January 30, 2023

**RE: Take 5 Oil Change
10415 Central Ave NE
Grading and Drainage Plans
Engineer's Stamp Date: No Date
Hydrology File: L21D059B**

Based upon the information provided in your submittal received 01/30/2023, the Grading & Drainage Plans **are not** approved for Building Permit, Grading Permit, and SO-19 Permit. The following comments need to be addressed for approval of the above referenced project:

POND VOLUME

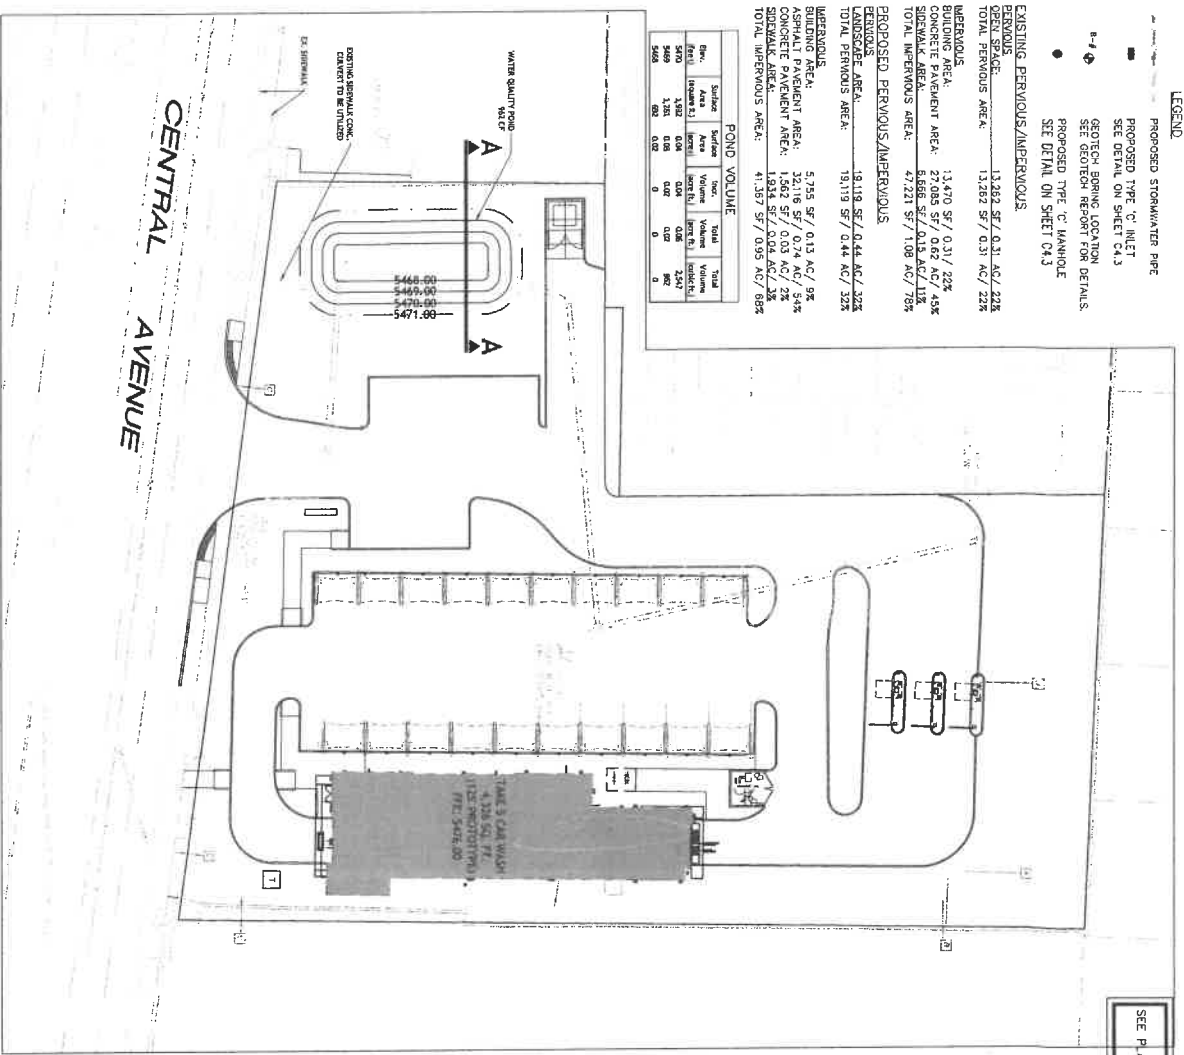
- Please provide a cross section for the stormwater quality pond showing the top of pond, bottom of pond and the SWQ required volume elevation. Please add a note, "Side slopes need to be stabilized with Native Grass Seed (per City Spec 1012) with Aggregate Mulch or equal (Must satisfy the "Final Stabilization criteria" CGP 2.2.14.b.)".

5. Please add the volume provided under the Stormwater Quality Calculations.
6. For the outfall of the SWQ pond, an outfall pipe connecting to the existing storm sewer system in Central is not needed. Instead, a two-foot or one-foot sidewalk culvert (depending on site's discharge) at the elevation of the required SWQ volume elevation at the pond and the existing flowline elevation at the curb is all that is needed. There is an existing sidewalk culvert for the existing site that may be utilized if in good condition.
